From: Anita Gardner
Sent: 19 December 2018 16:32
To: Planning.Responses
Subject: FW: CM/31/18/L - The Dairy Brookpit Lane,, Climping, Insertion of an internal widow
Attachments: 05B Plan Elevations proposed _ Layout.pdf

From: Andrew Fuller [REDACTED]
Sent: 19 December 2018 16:06
To: Anita Gardner
Cc: [REDACTED]
Subject: Re: CM/31/18/L - The Dairy Brookpit Lane,, Climping, Insertion of an internal widow

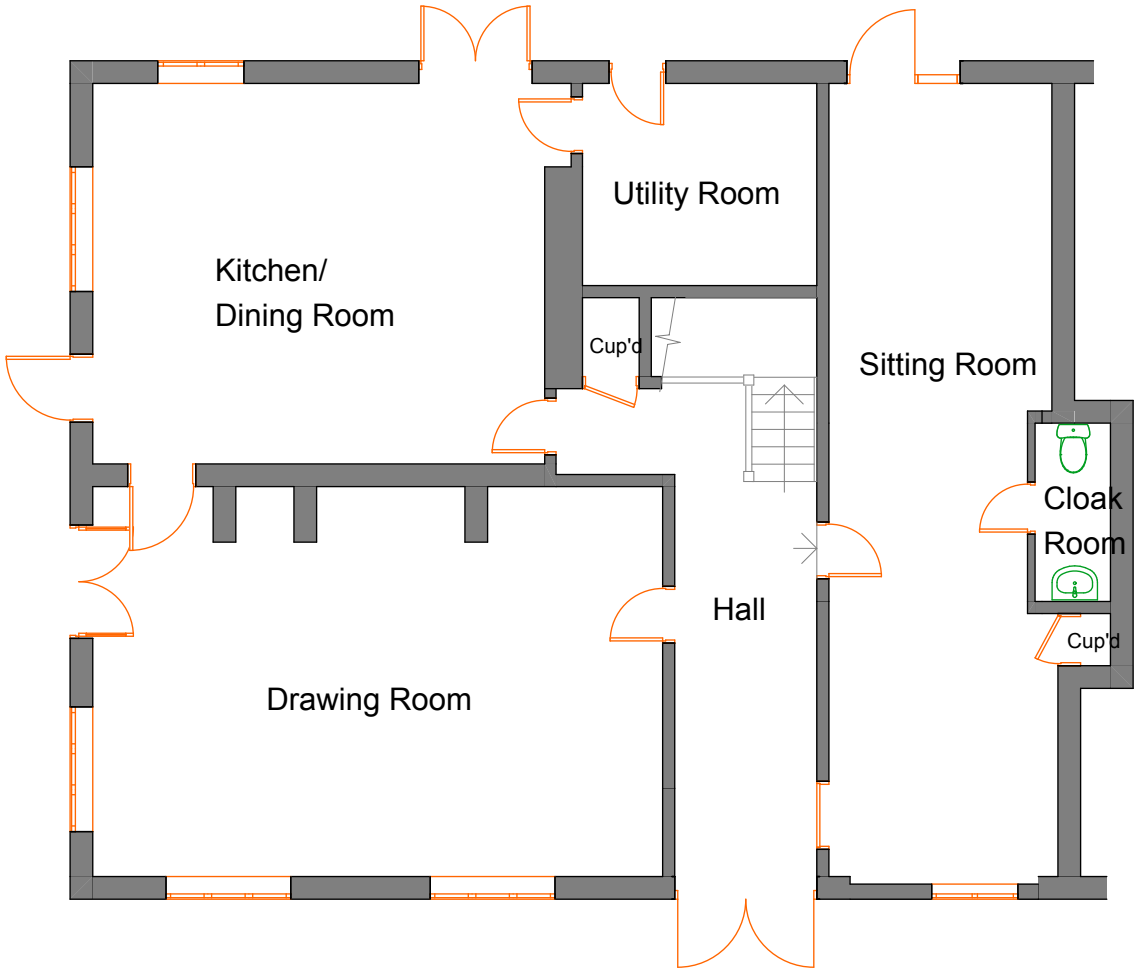
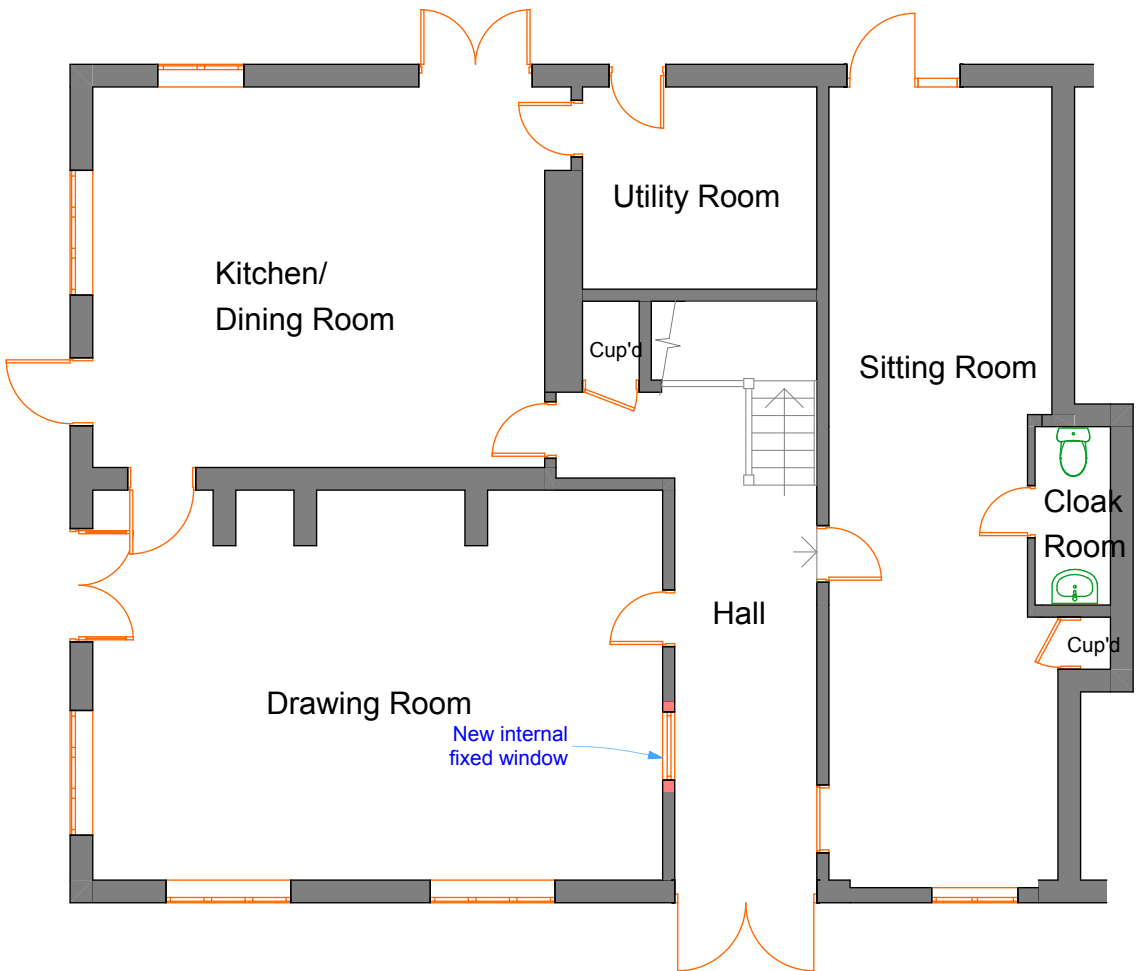
The above application contains no internal elevation of the window and this is required to show its position and size in the wall. Without prejudice, please can you let me have the relevant plans within the next 5 days.

Please find attached our drawing updated to include existing internal glazing, together with an internal elevation of the window proposal.
